# DRAINAGE LETTER

## 7280 N. NEVADA LANE

PCD File: [PPR2411](#)

SUBJECT: Drainage Letter, 7280 N. Nevada Lane

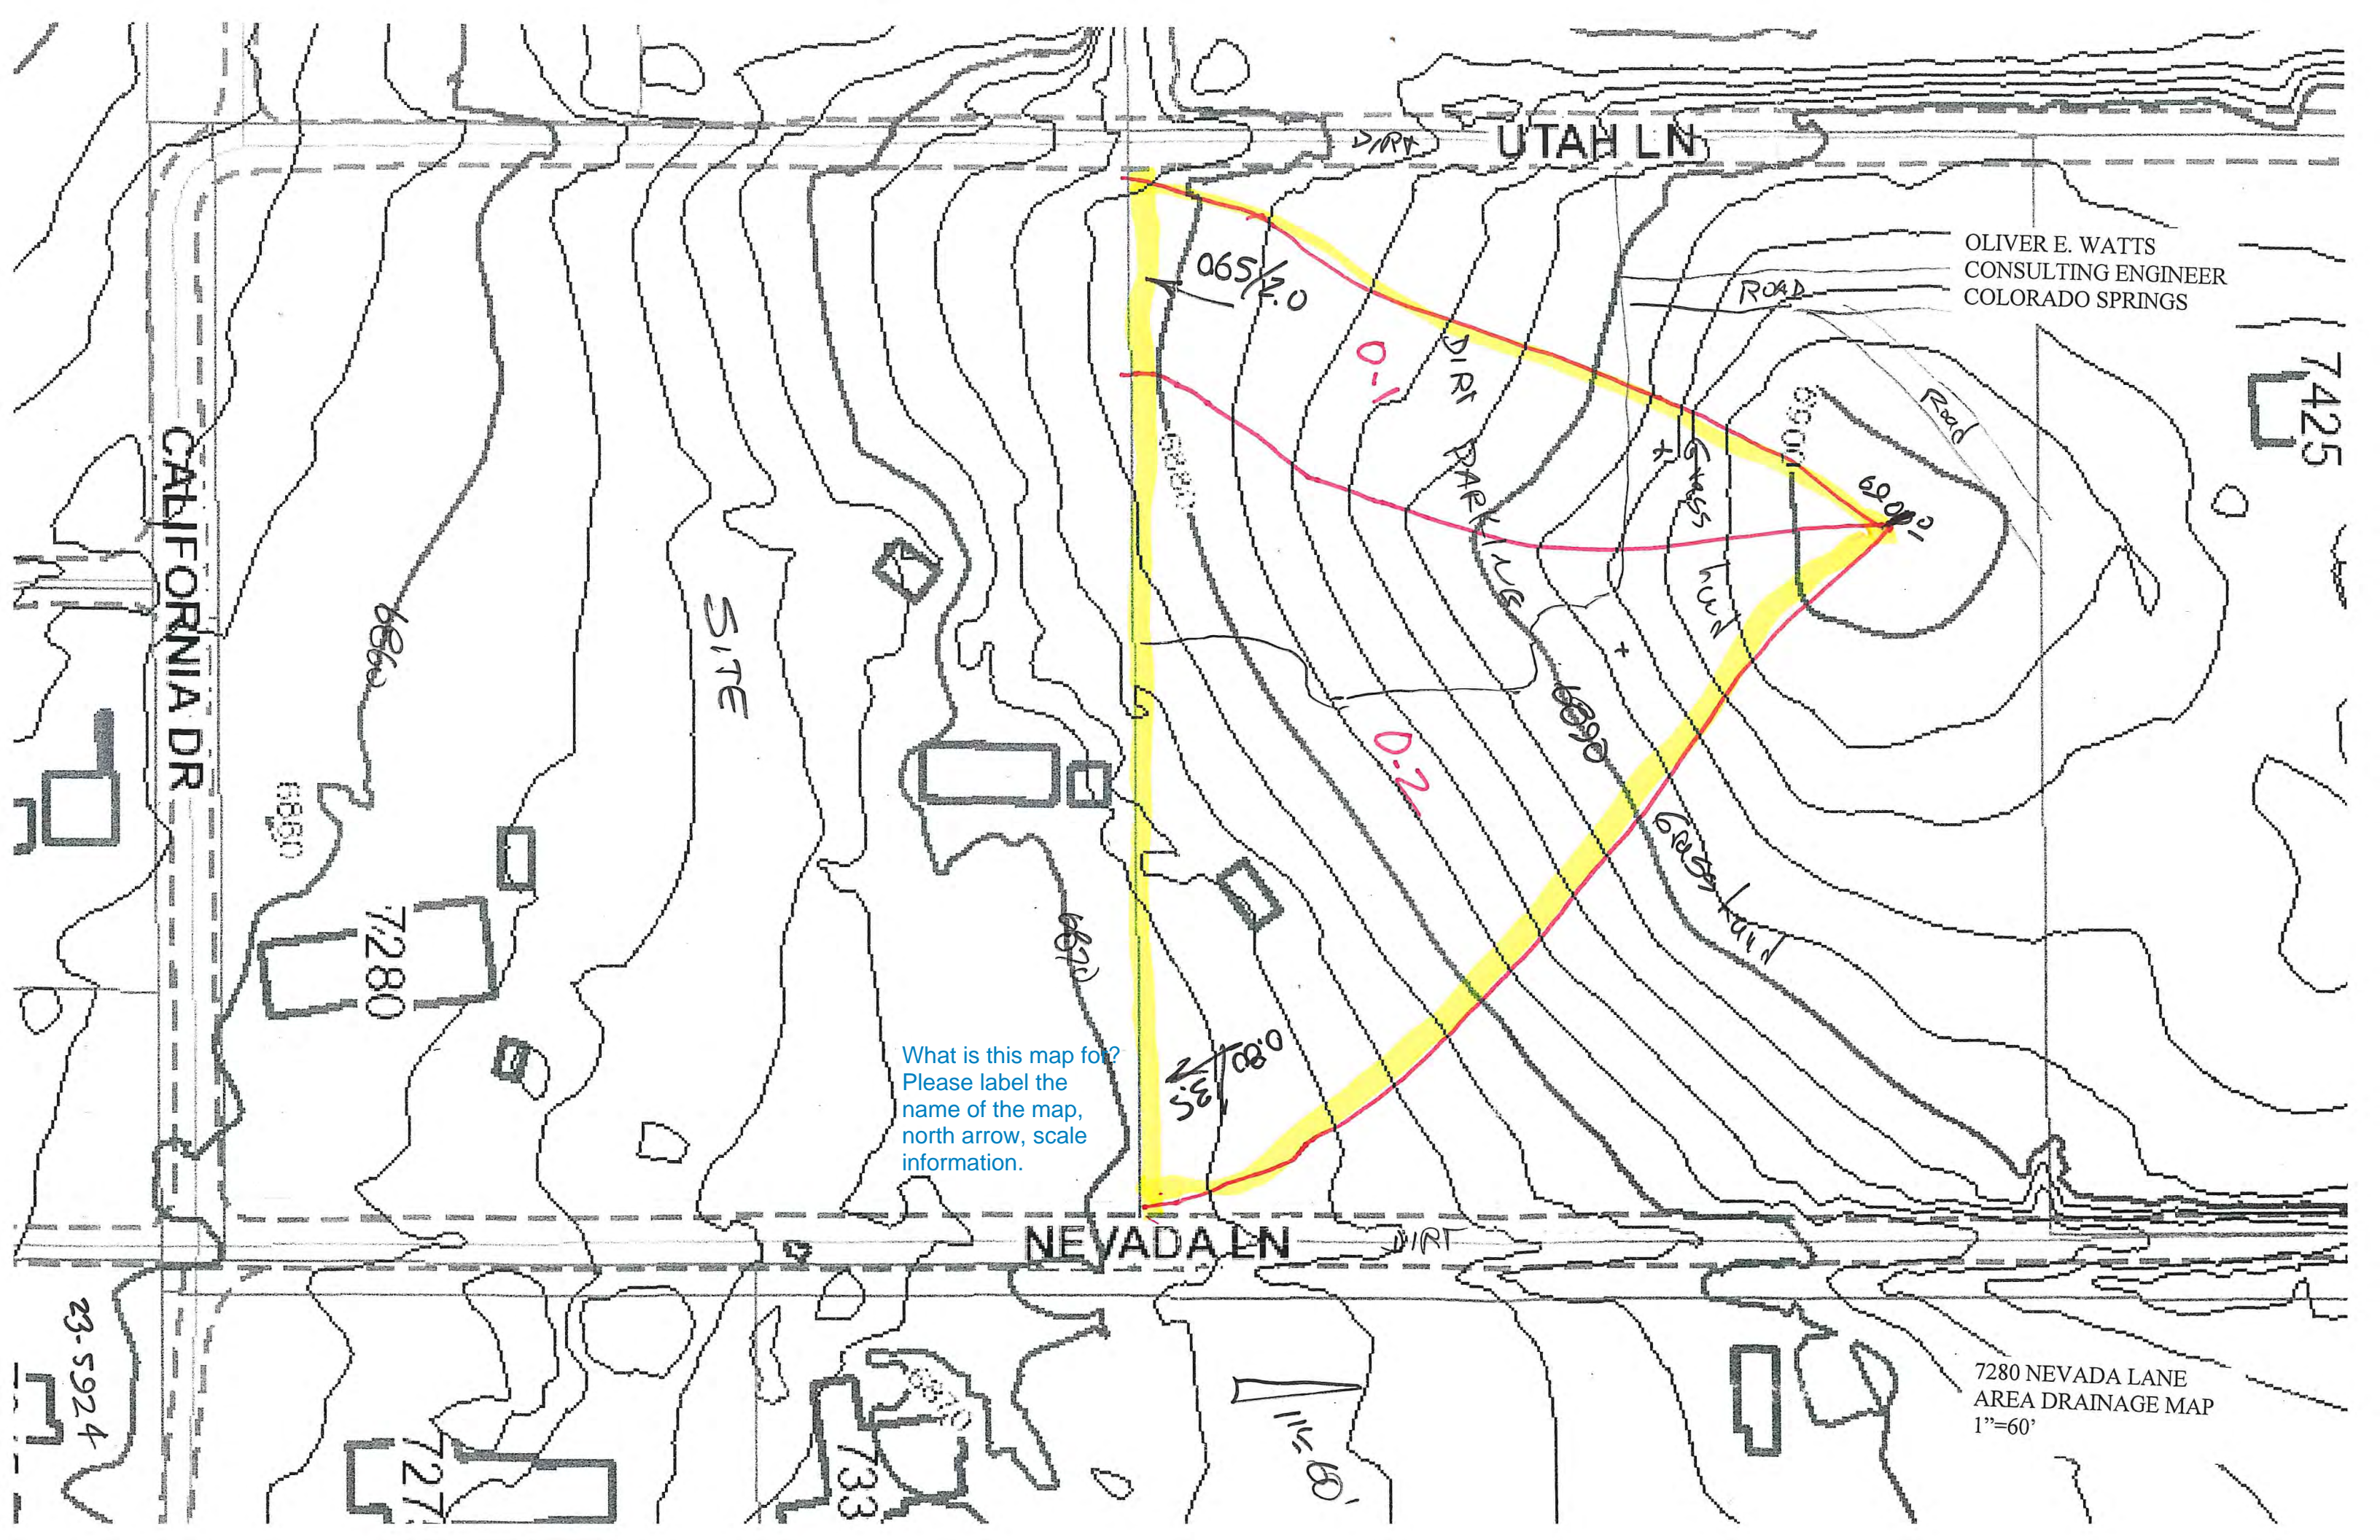
What is this map for?  
Please label the  
name of the map,  
north arrow, scale  
information.

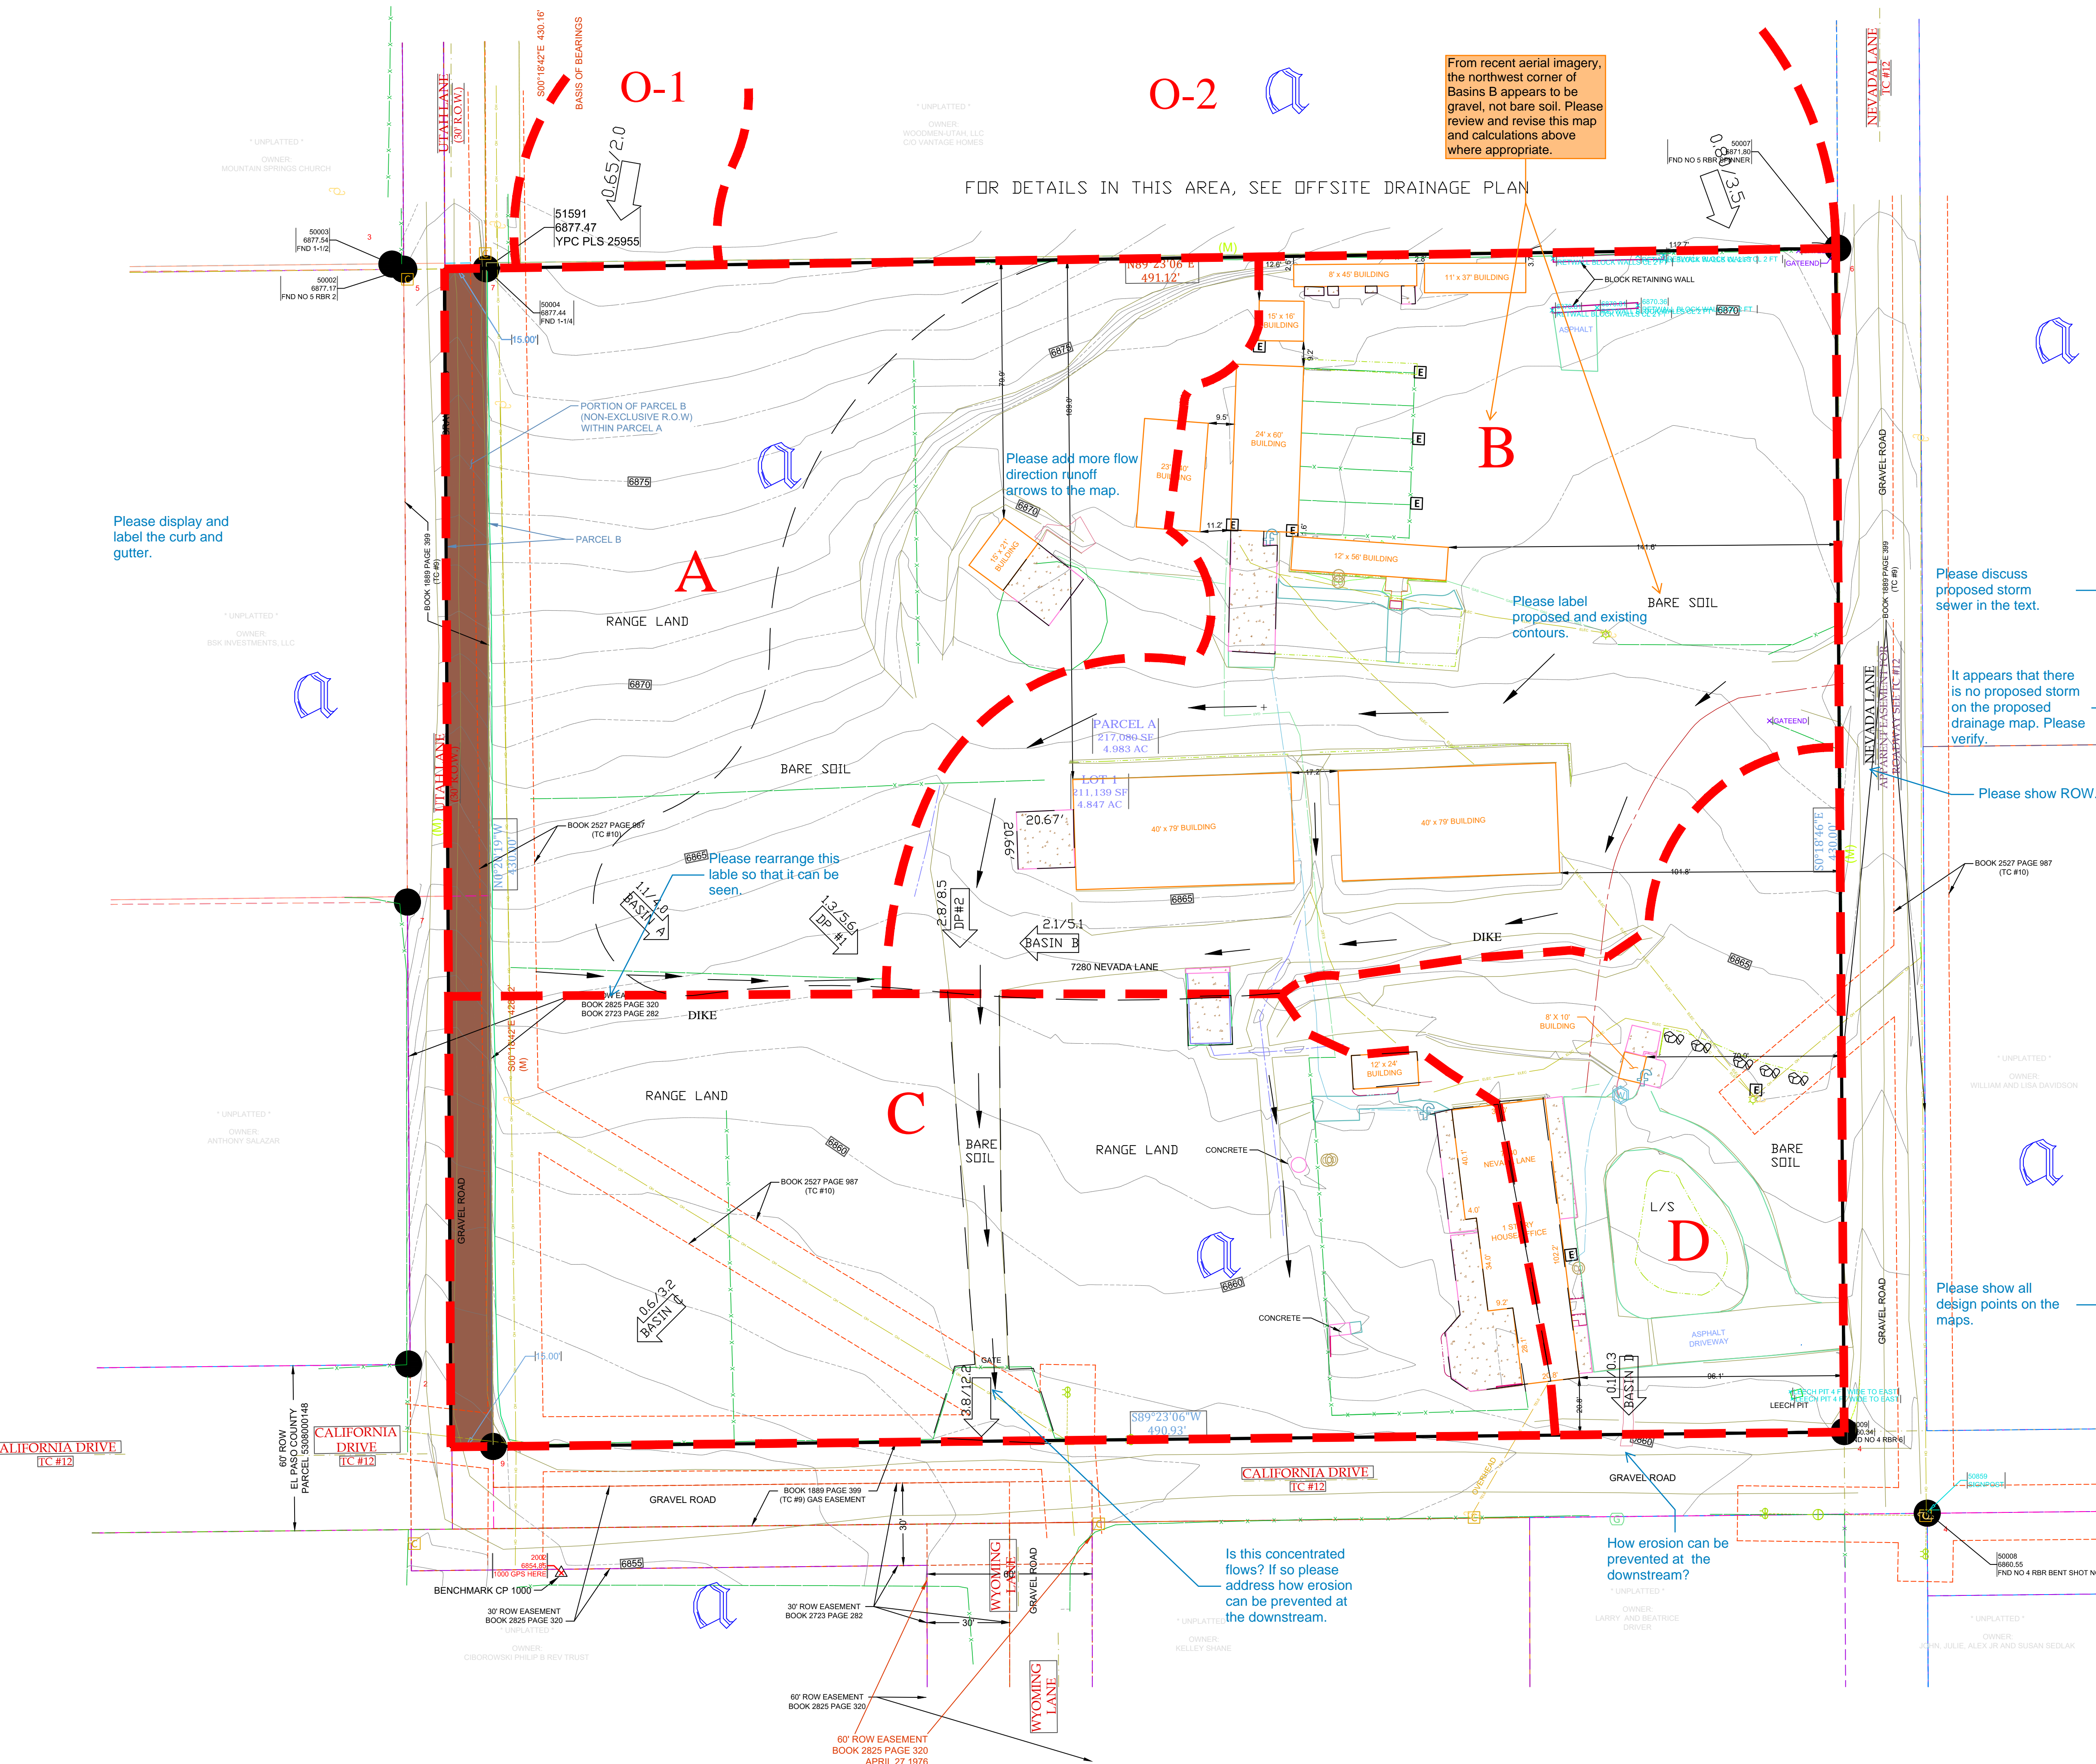
An existing drainage map is required.

From recent aerial imagery, the northwest corner of Basins B appears to be gravel, not bare soil. Please review and revise this map and calculations above where appropriate.

Please discuss proposed storm sewer in the text.

It appears that there is no proposed storm on the proposed drainage map. Please verify.

Please show ROW.

All proposed drainage basins, and design points need to be discussed in the text.

Please show all design points on the maps.

Please display and label the curb and gutter.

Please add more flow direction runoff arrows to the map.

Please label proposed and existing contours.

Is this concentrated flows? If so please address how erosion can be prevented at the downstream.

How erosion can be prevented at the downstream?
